Consultation Response from KC Landscape

Application No:	2023/93704
Proposed Development:	Erection of 10 dwellings and associated works [amended to 12 (Sept 2024)]
Location:	land northwest of, Urban Terrace, Denby Lane, Grange Moor, Huddersfield, WF4 4EB
Applicant/Agent:	Broadgrove Planning & Development Ltd
Planning Officer	William Simcock
Date Responded:	25.09.2024
Responding Officer:	Landscape
Responding Ref:	MM126

1 Proposed Site Layout

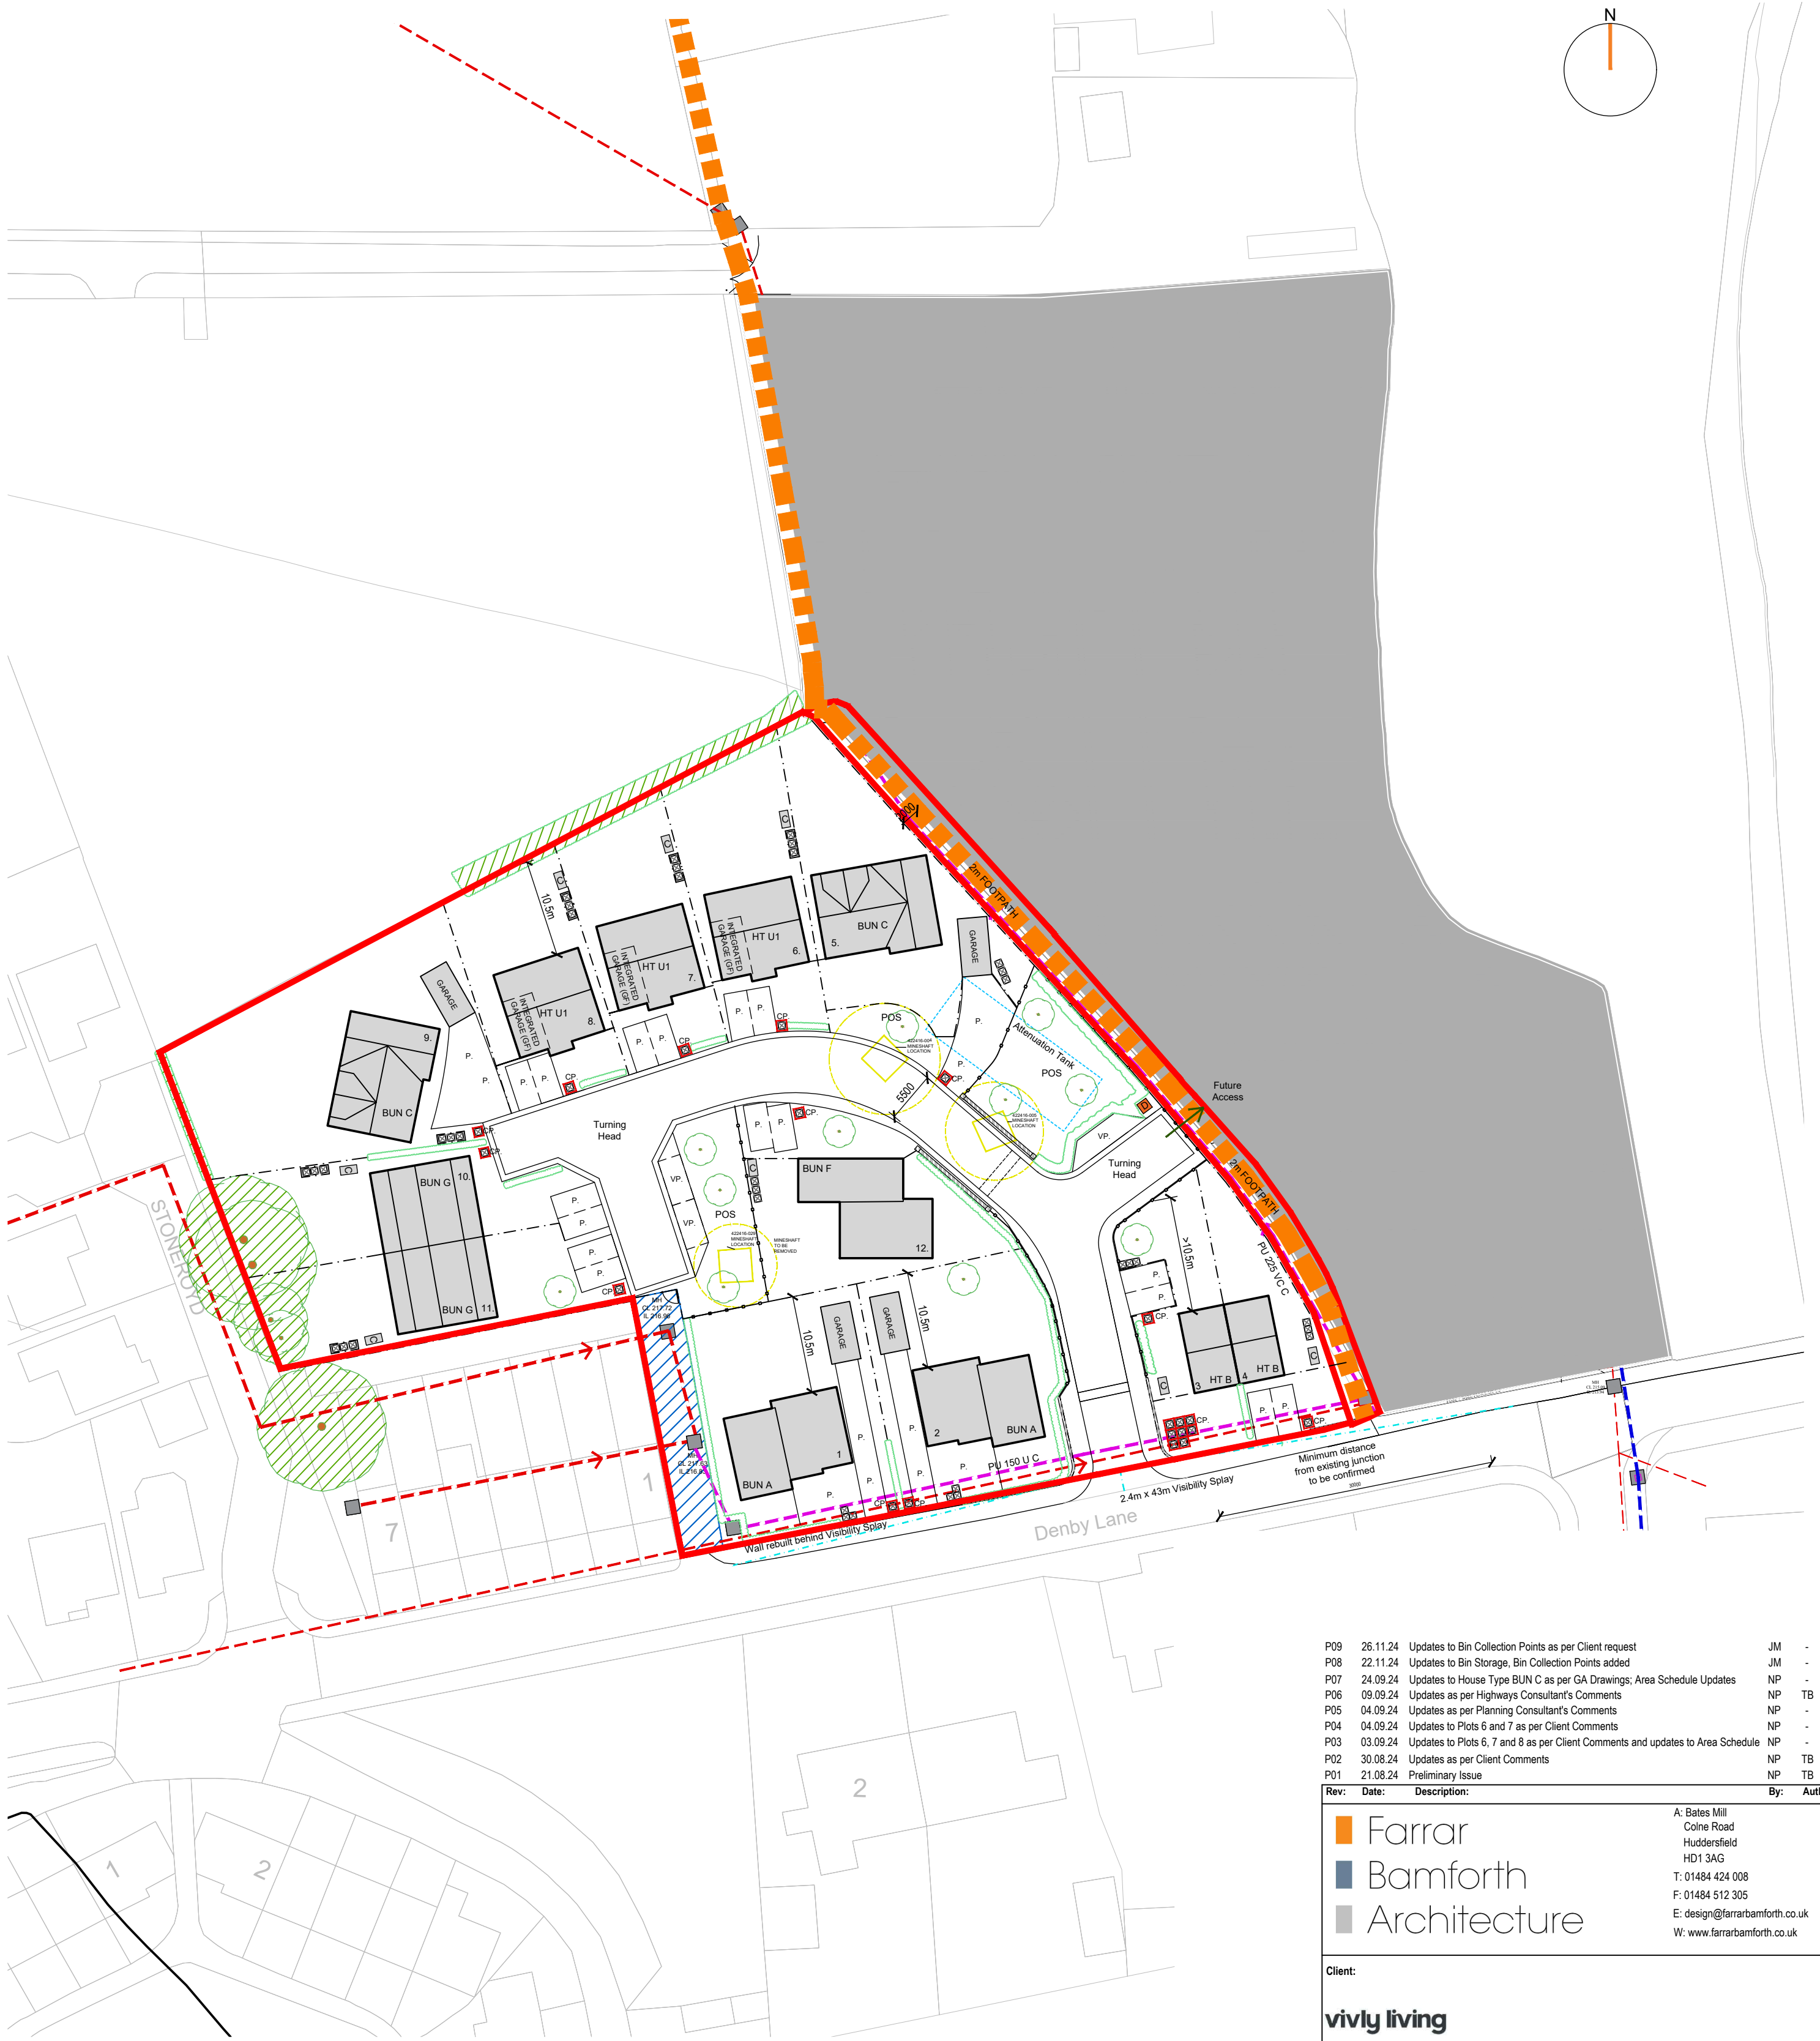
Submission of measured areas and typologies of open space to meet requirements of LP63 is required as per validation checklist. Please confirm measured areas for the on site pos and typologies for the calculations.

1. The plan for the open space and usage by the public is very indicative in landscape terms, therefore difficult to provide meaningful comments, however, some greenspace on site is shown and is welcome, as outlined in the D&A statement (above) however, consider access and purpose of the spaces being created. Will the spaces provided meet the needs of the widest possible range of users, be easily accessible and enjoyed by all people, regardless of visual, physical and cognitive ability, mobility or age.

2. The area more likely a highways verge is in front of property no 5. There looks to be no access to the

area over the attenuation tank and this is proposed wildflower mix so is public accessibility for all even anticipated here?

3. Greenspace on site is welcome, however, consider access and their purpose (and typology). Will the space provided meet the needs of the widest possible range of users, be easily accessible and enjoyed by all people, regardless of visual, physical and cognitive ability, mobility or age.

Required Actions- confirmation of accessibility and use of the public open spaces

Revision of landscaping plan to address comments above
